Environmental Health Consultation Response

To	Mr S Davis
Date	12-08-2026
Planning Ref	P/99/26/PL
Site Description	Holiday Site Lagnersh House Lower Bognor Road Lagness West Sussex
Date of Application	2026-07-31 00:00:00
Category	Application
Recommendation	No Objection No Objection – with conditions Objection Holding Objection

drawing title:
Block Plan

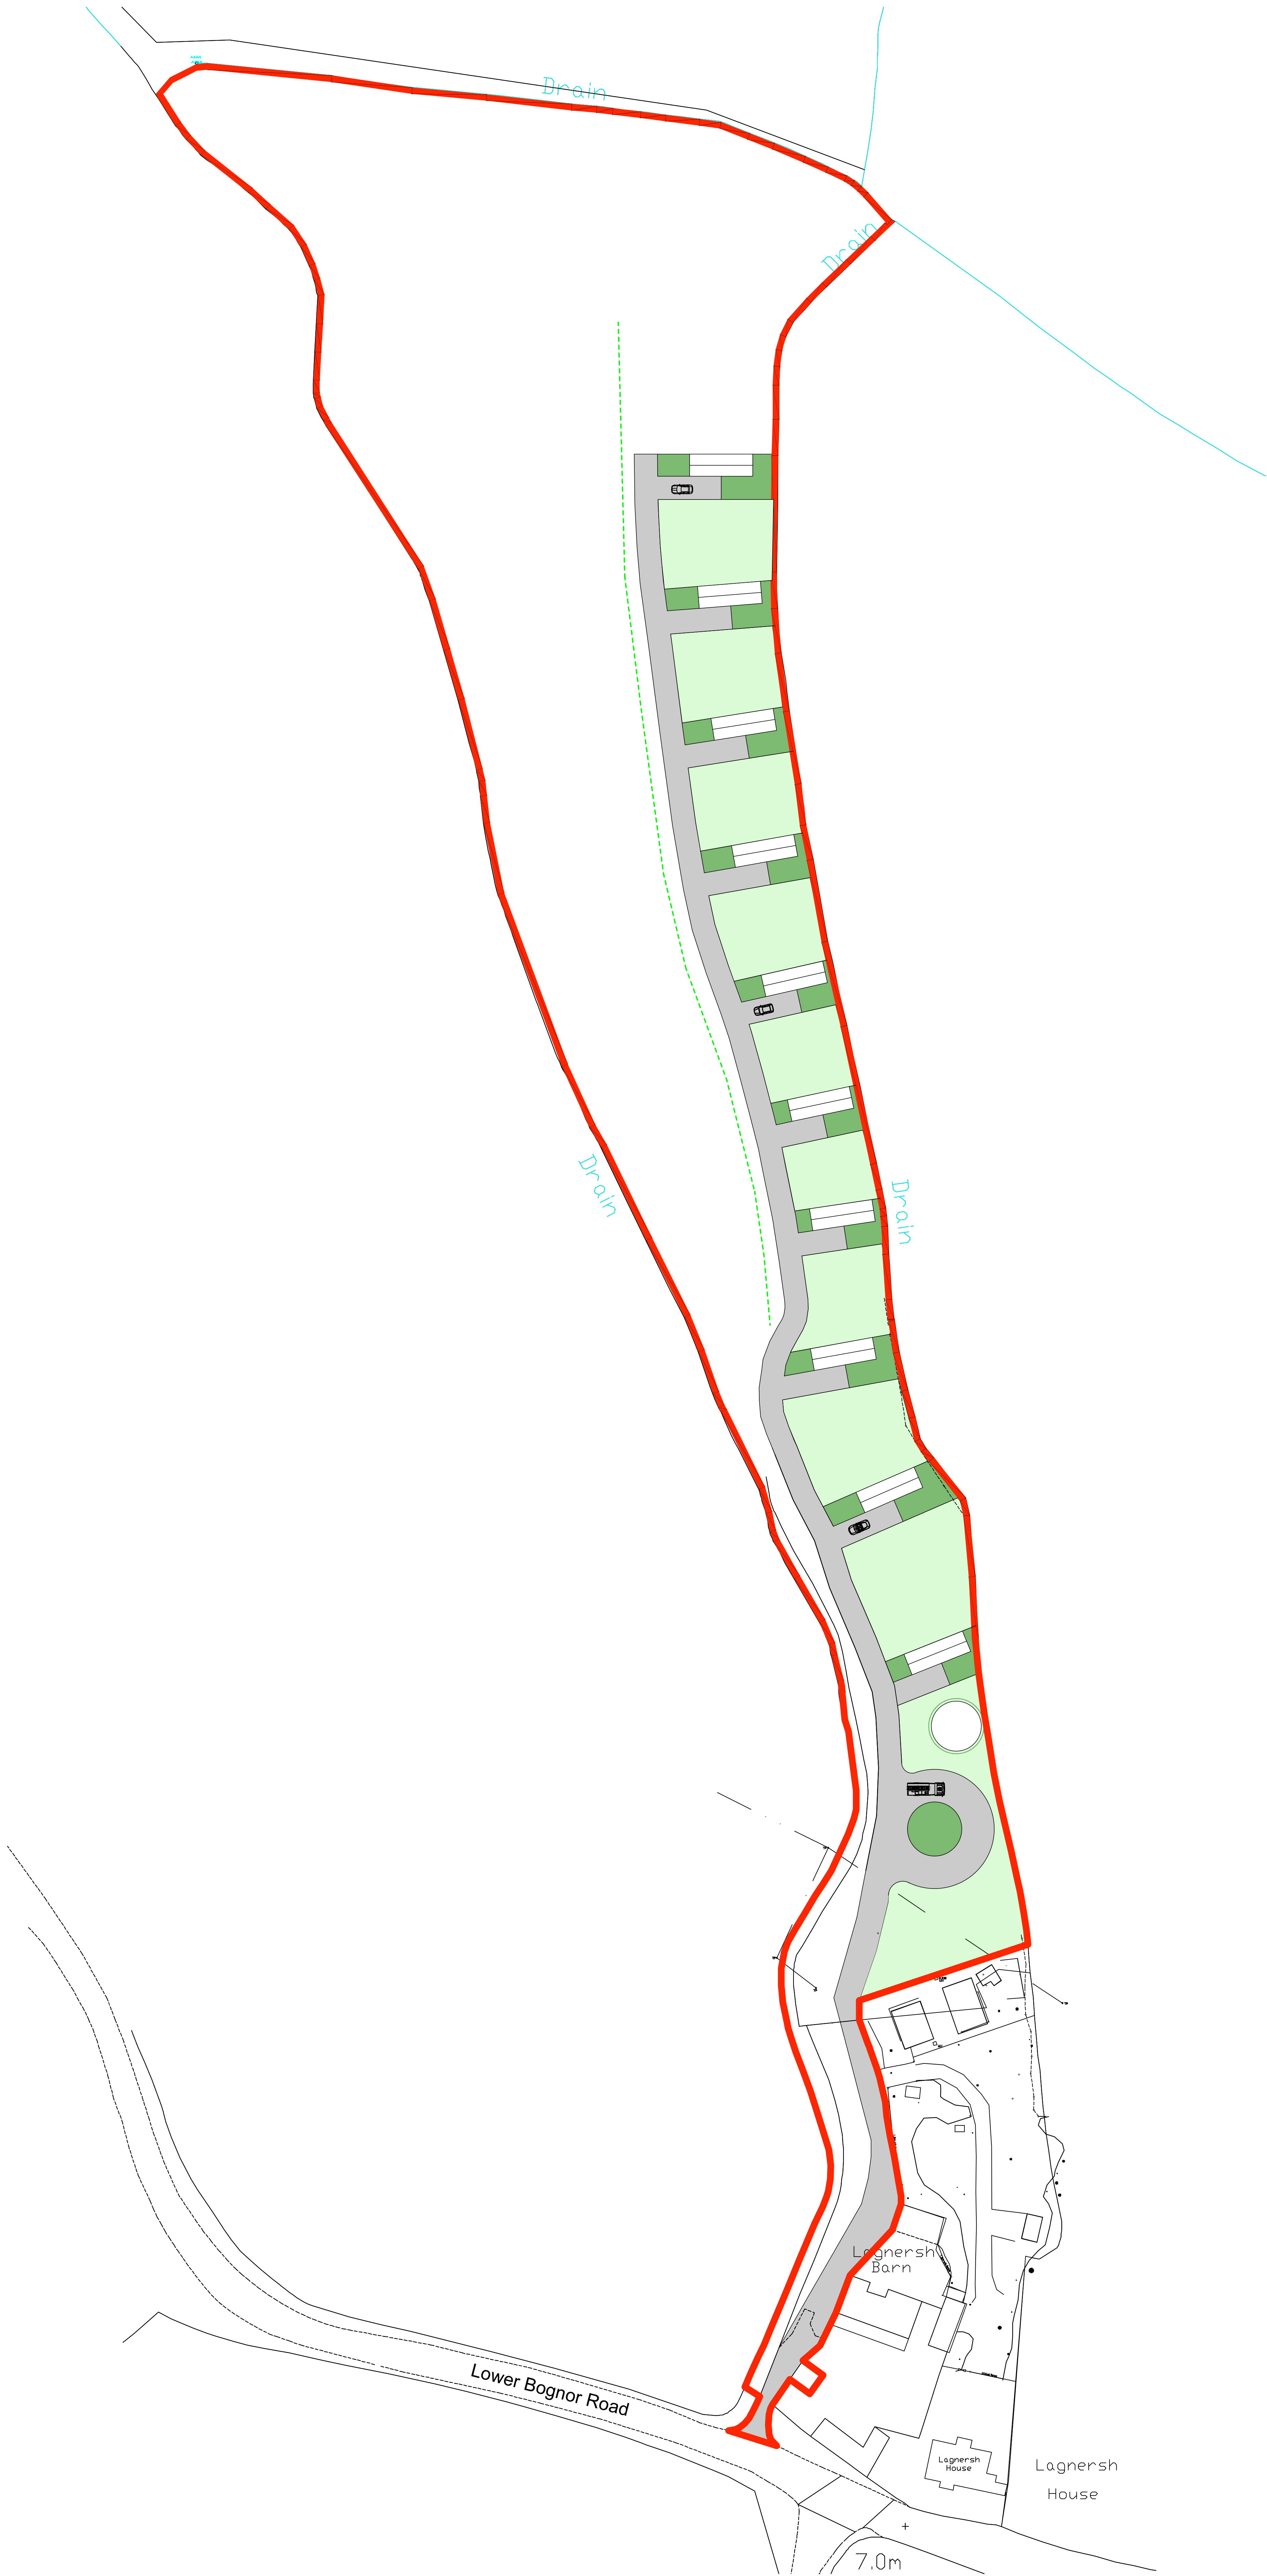
It is also unclear whether the area to the south of the site, marked as a proposed turning circle and water tank, is within the same ownership as the remainder of the site or whether it has yet to be purchased and cannot therefore be considered as part of this application.
